Reference	Respondent	Question	Response
<b>1 - Miscellaneous and General</b>			
MG1.1.22	The Applicant Portsmouth City Council	Does Portsmouth City Council accept that it would take responsibility for the maintenance of the proposed landscape planting at the landfall after 5 years of establishment, as suggested at 1.6.4.1 of the Outline Landscape and Biodiversity Strategy [APP-506]?	<p>Portsmouth City Council (PCC) would wish to contain control of all relevant parts of our land. Whether maintenance responsibility should sensibly pass to PCC would be dependent on whether that landscaping was on land retained by PCC or on land that has passed into the applicant's control or ownership. If the proposed landscaping was on land that has passed into the applicant's ownership PCC would not expect to be burdened with the maintenance of it but would expect an appropriate requirement to approve a landscaping scheme and require the applicant to maintain it to fulfil its amenity and other purposes.</p> <p>Where landscaping is proposed on land retained by PCC the Council would accept the responsibility for maintenance after 5 years of establishment but an appropriate commuted sum to be paid by th

**AQUIND Interconnector
Hedgerow and Tree Preservation Order Plans**

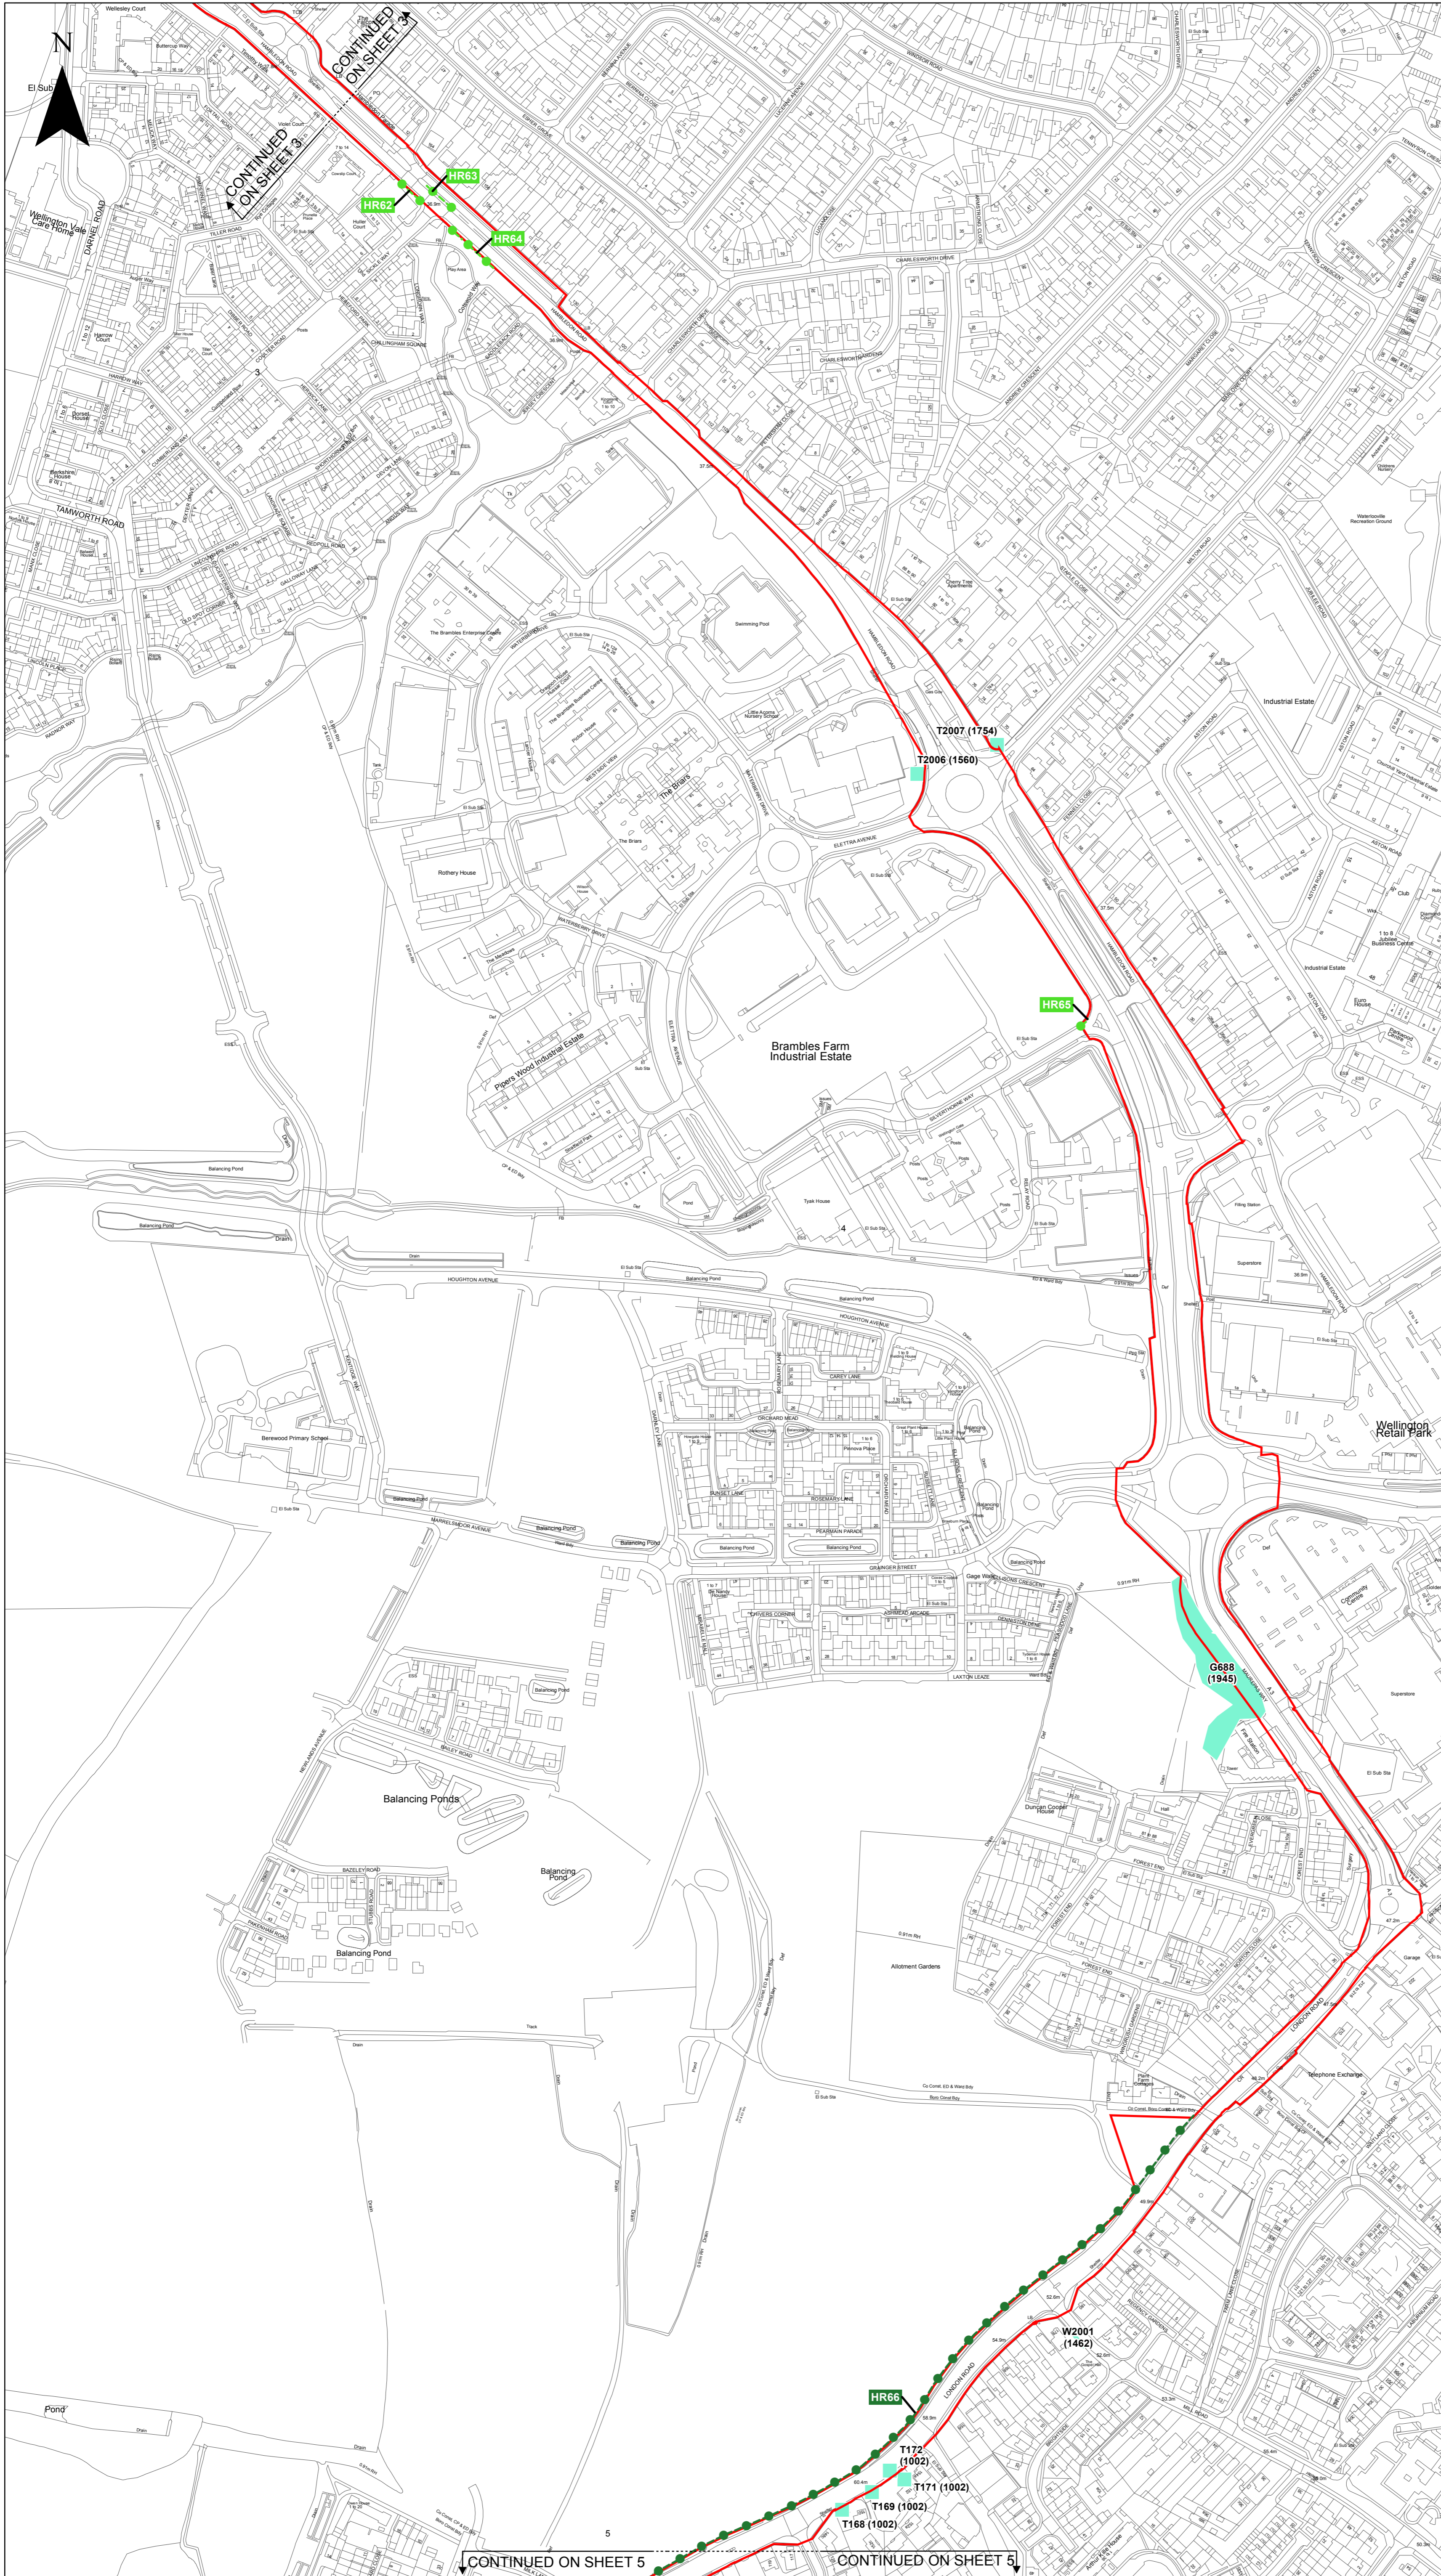
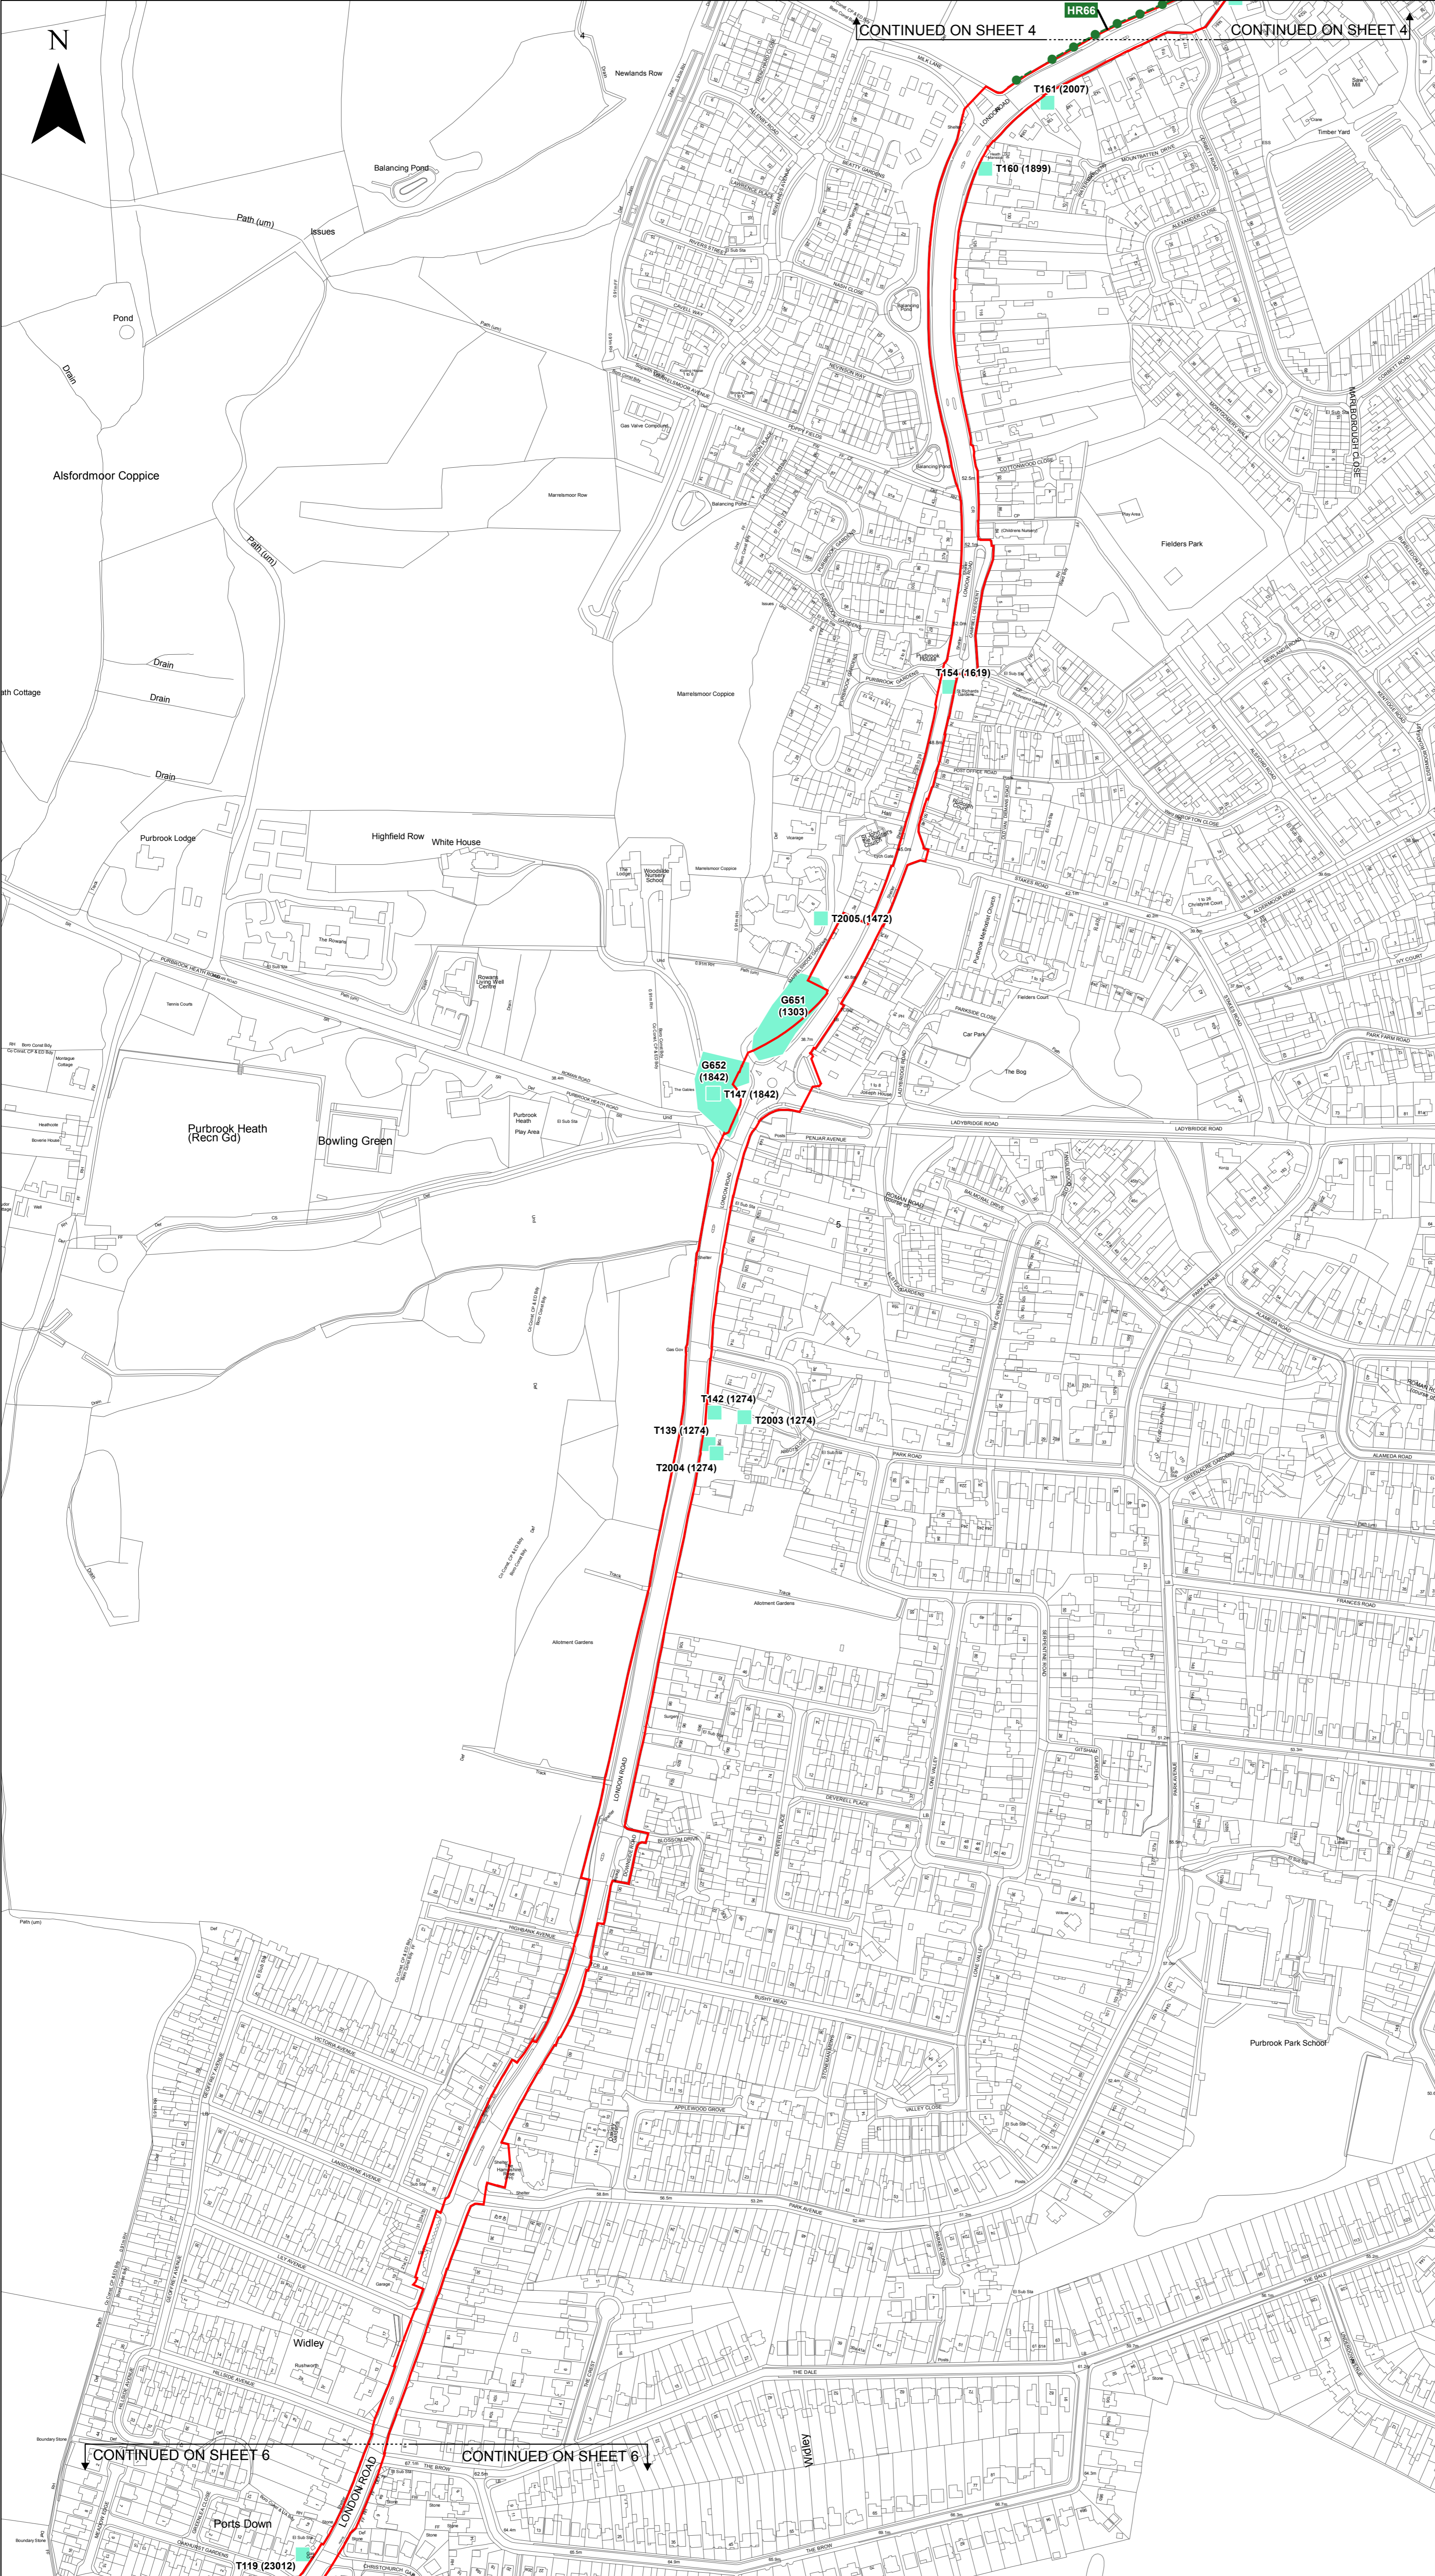
The Applicant seeks powers over any tree in the Order limits rather than providing a schedule (as per model provisions and as is usual in other recently made DCOs). Schedule 11 of the dDCO [APP-019] (TPO trees) only lists 'potential removal' and 'indicative works to be carried out'. How can this be specific enough to understand the impact of the Proposed Development on trees? If this remains unchanged, should the ExA in weighing the benefits and disbenefits of the Proposed Development therefore assume the loss all of the trees within the Order limits during construction and throughout the lifetime of the Proposed Development, given that 42(2)(b) of the dDCO [APP-018] removes any duty to replace lost trees?	<p>All trees to be impacted upon must be individually identified and work proposals specified in a detailed schedule.</p> <p>If this remains unchanged, the ExA must in weighing the benefits and disbenefits of the Proposed Development assume the loss all of the trees within the Order limits during construction and throughout the lifetime of the Proposed Development, given that the proposal at 42(2)(b) of the dDCO [APP-018] removes any duty to replace lost trees?</p> <p>The potential for unmitigated loss of amenity and eco system services provided by the city's trees is huge.</p> <p>The breadth of article 41 is unacceptable and displays a lack of understanding of how local authorities manage their trees, approaching the matter through a misguidedly legalistic lens. Even then, as highlighted, Schedule 11 only engages with TPO protected trees at a disappointingly high level. The applicant may seek to argue the need for operational flexibility justifies the "potential" removals listed in Schedule 11 or the wording of Articles 41 and 42, but without any further requirement to obtain permission it must be assumed that arts 41(1) and 42(1) will result in the felling of all trees if it is commercially expedient to the undertaker. In the case of 41(1) this would occur without obliging the applicant to have regard to the amenity or other value of any tree, no matter how mature or otherwise noteworthy.</p> <p>A phased approach (such as that seen in relation to archaeology and with particular sensitivity to site clearance works falling within Onshore Site Preparation Works) could be taken for the local planning authority to approve any felling or works to trees located on land in which PCC has a legal interest, and confirm precisely which trees are not intended to be felled or subject to works. Further approval from the local planning authority should be sought to confirm that other such trees shall not be felled or worked upon (without any deeming provisions) following commencement. Such approvals for non-TPO trees should empower the local planning authority to be able to enforce appropriate replacement trees.</p>

Reference	Respondent	Question	Response
			<p>Given the requested exemption from re-planting obligations, the oversight of the local planning authority is especially important to ensure that the undertaker is accountable for its actions in relation to trees. The apparent disregard for trees as protected public assets gives PCC serious concern about whether they retain the relevant technical skills and understanding of balancing the public interest to make appropriate decisions about works to trees. The undertaker's powers should be curtailed in relation to trees and subject to local planning authority approval in relation to all trees on land in which PCC has a legal interest. It is noted that the Thanet DCO, Article 34, only granted the undertaker the power to fell or lop only those trees made subject to a TPO after July 2017, being a year before the application was accepted for examination.</p>
